KENDALL BAY REMEDIATION PROJECT

RAP ADDENDUM

PREPARED FOR JEMENA LIMITED

Final | 22 June 2018

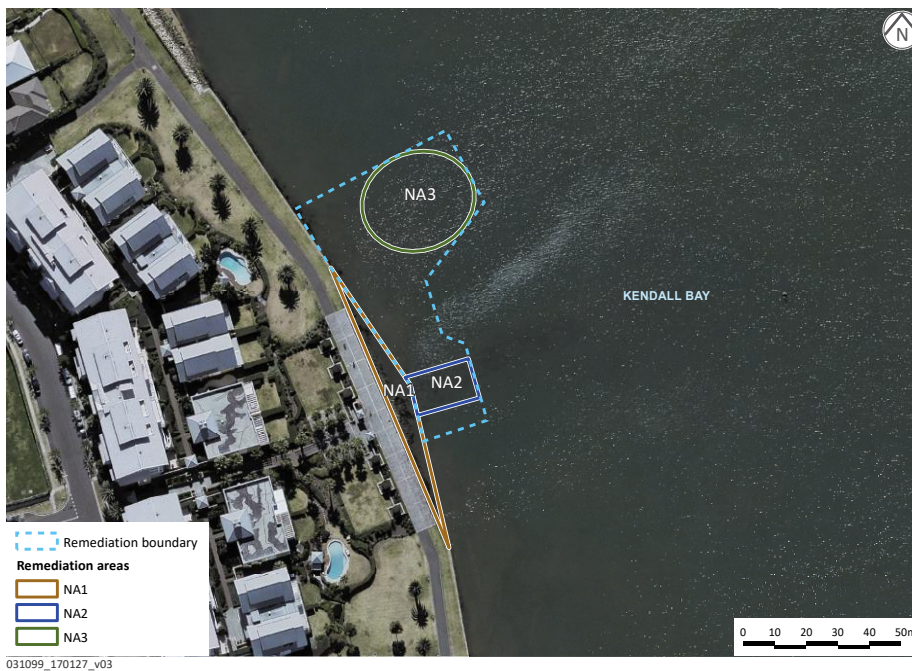
This report considers the part of the Remediation Area in the southern part of Kendall Bay should be slightly modified by moving the north-western boundary of remediation sub-area SA3 to include the south-western corner of Cell 41, as shown in **Figure 1-1**. Such an approach would result in sample locations SS04, HH2_10, B8, B11 and SHA15 being included in the Remediation Area. Such a change would:

- Increase the southern Remediation Area by 2,230 m², consisting of a 1,930 m² area from the southern part of cell 41 and a 300 m² area from the southern part of cell 39;

- Address the health risk exceedance at location SS04 together with aesthetic impacts in this area;
- Provide additional health protection for recreational users of Kendall Bay by addressing uncertainties associated with a transition from a 'source area' exposure scenario at sample location SS04 to a 'beach area' exposure scenario at sample locations HH2_10, B8 and B11;
